**Re: REQUEST FOR SEARs FOR THE REDEVELOPMENT OF THE HARBOURSIDE
SHOPPING CENTRE, DARLING HARBOUR (SSD 7375)**

SHFA Design and Development Advisory Panel comments to the Applicant – October 2015

site analysis and opportunities diagram

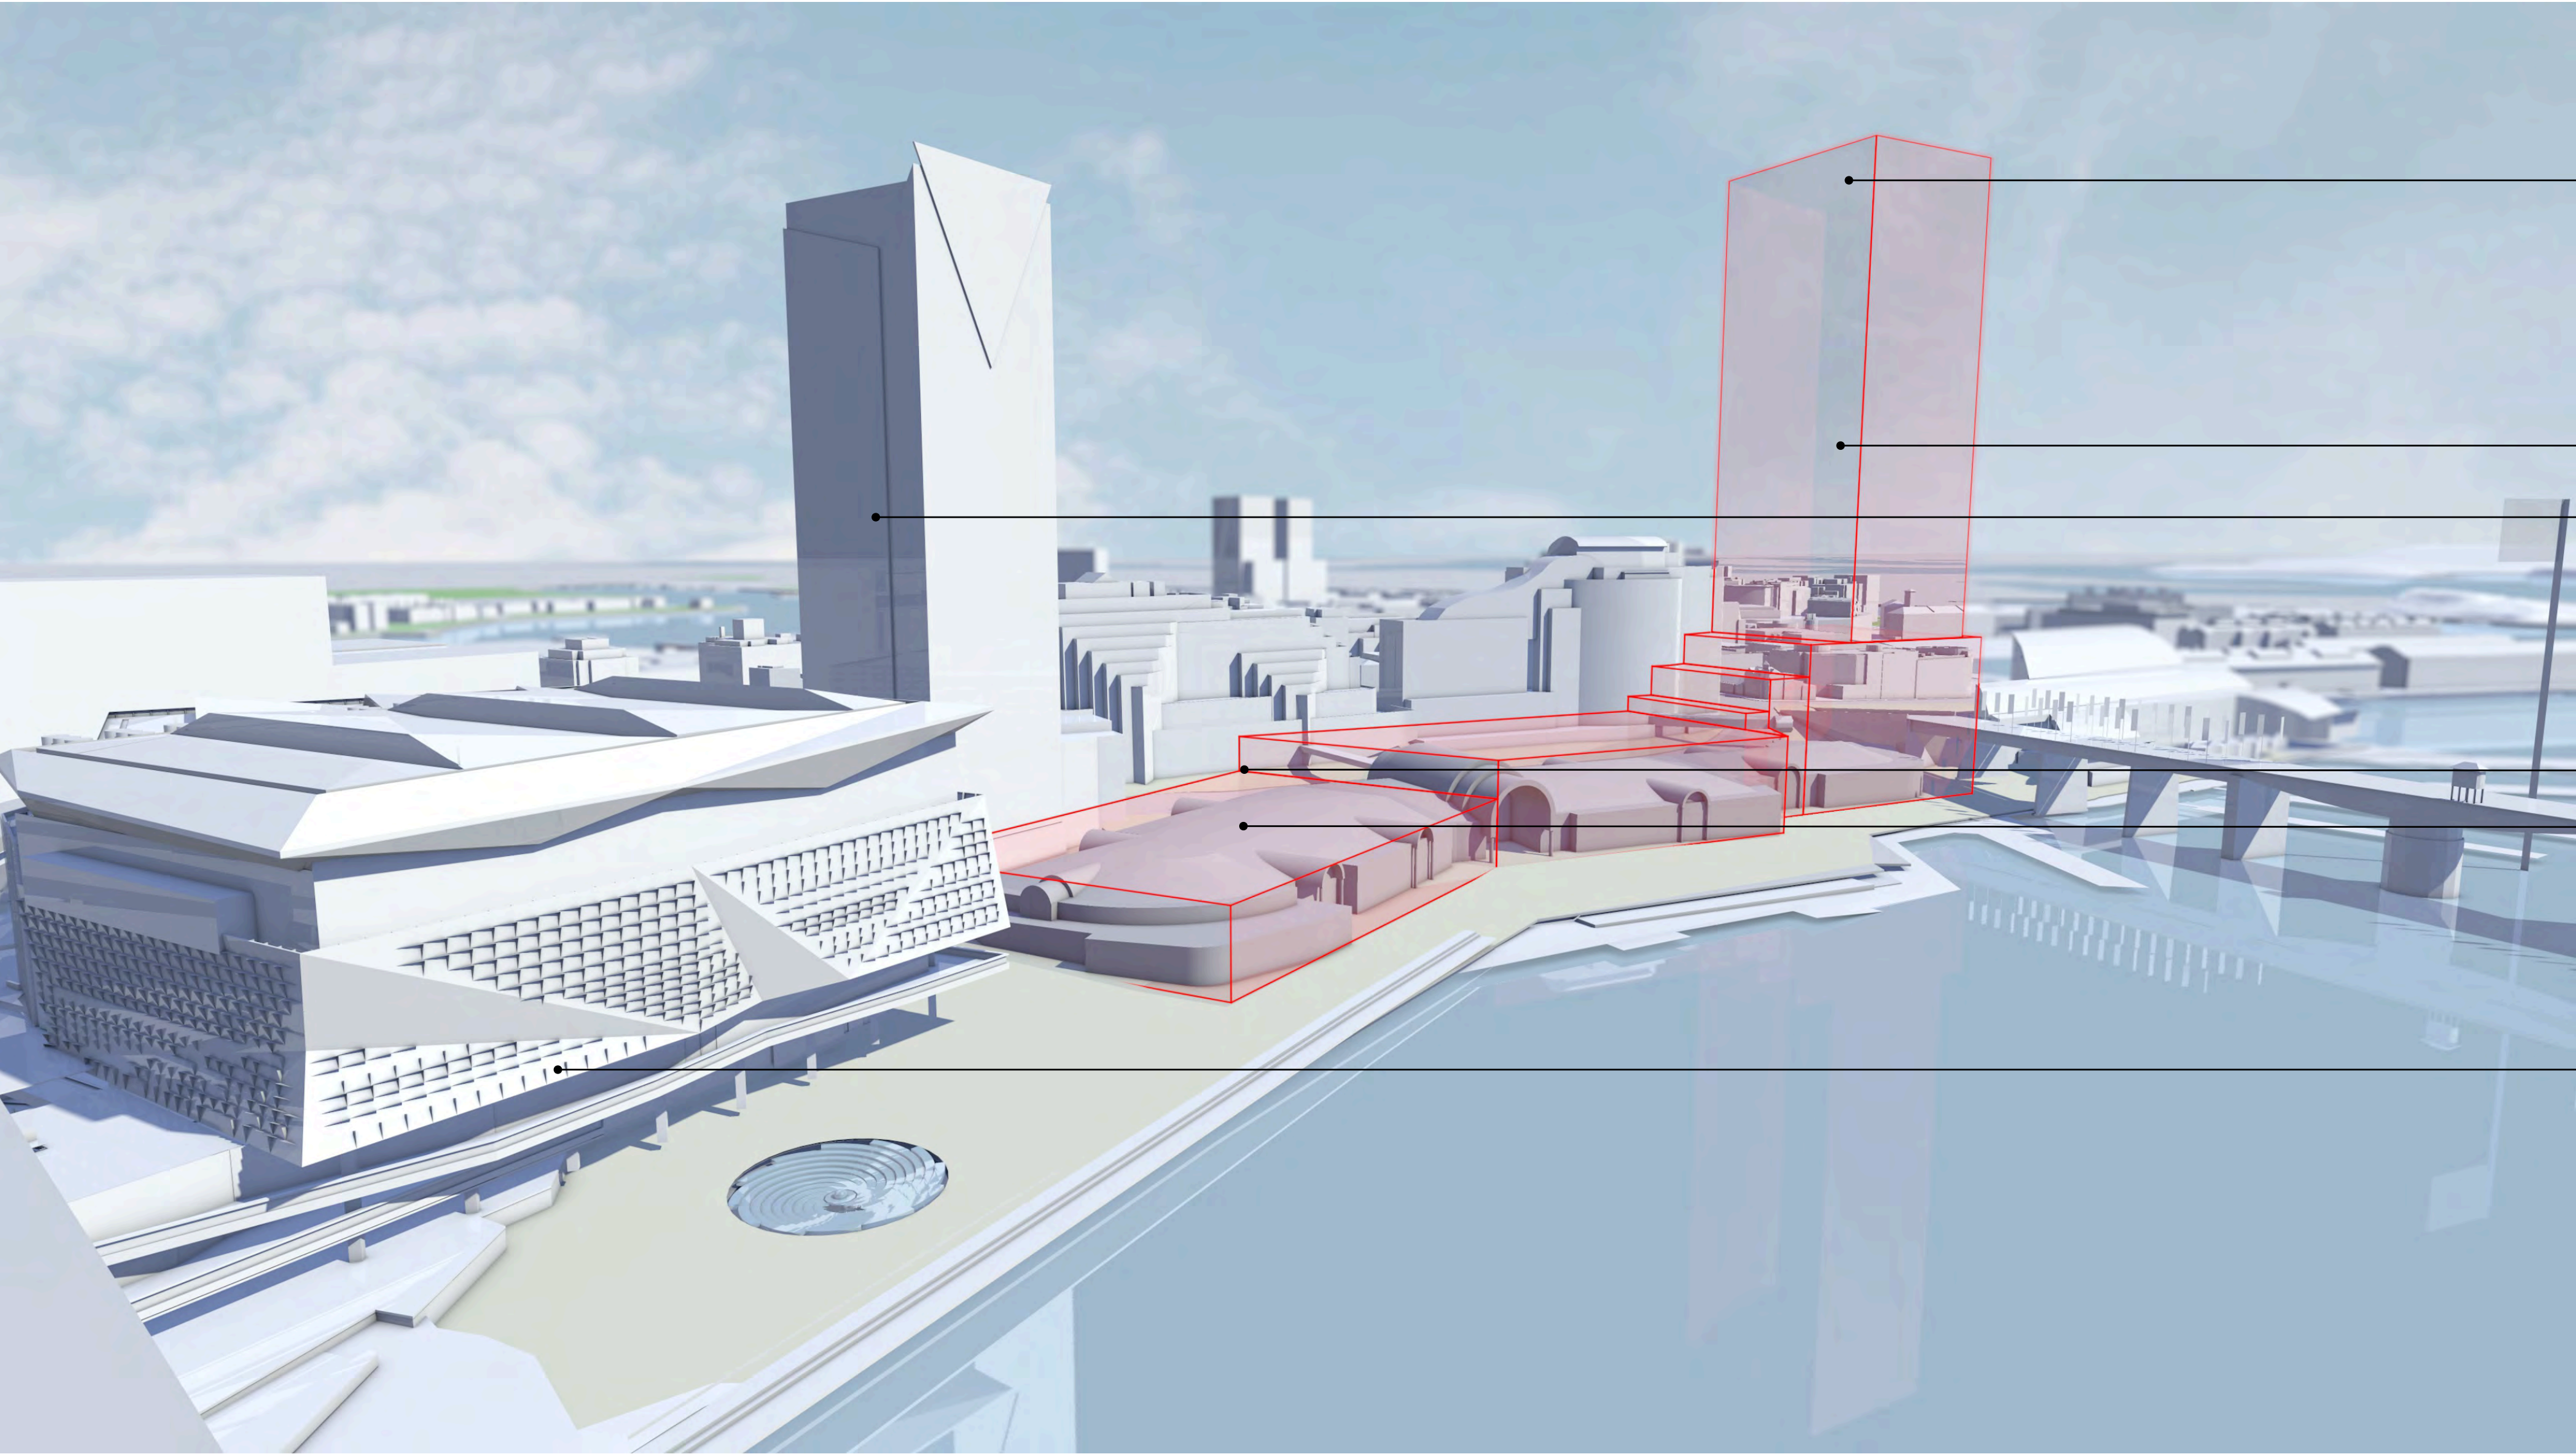
The Panel raised concerns about the height and location of the proposed tower, the towers impact on the heritage of the Pyrmont Bridge and its overshadowing, particularly in relation to the public domain. It also raised concern about the towers fit with the precinct on the western side of Cockle Bay and the importance of maintaining and improving the public waterfront promenade.

- The concept of terracing the building and stepping down to the public domain was supported as was the demolition of the existing development.
- The relocation of the tower further south was suggested.
- Consideration to more than one tower with lower heights was suggested.
- Overshadowing from the tower, particularly in relation to public domain including the waterfront, is a significant issue and concern.
- The location of the tower relative to the Pyrmont Bridge was raised as it presents an unsatisfactory relationship.

- Pymont Bridge is one of few heritage items in Darling Harbour, and needs to be reinforced, not diminished, so it reads as a strong, independent historic structure.
- There is an opportunity to improve the legibility of and the connections to the historic Pymont Bridge which needs to be developed.
- The location of the tower relative to the Pymont Bridge was raised as it presents an unsatisfactory relationship.
- It was suggested the tower could be pushed back to allow for a better design reading of the historic Pymont Bridge.
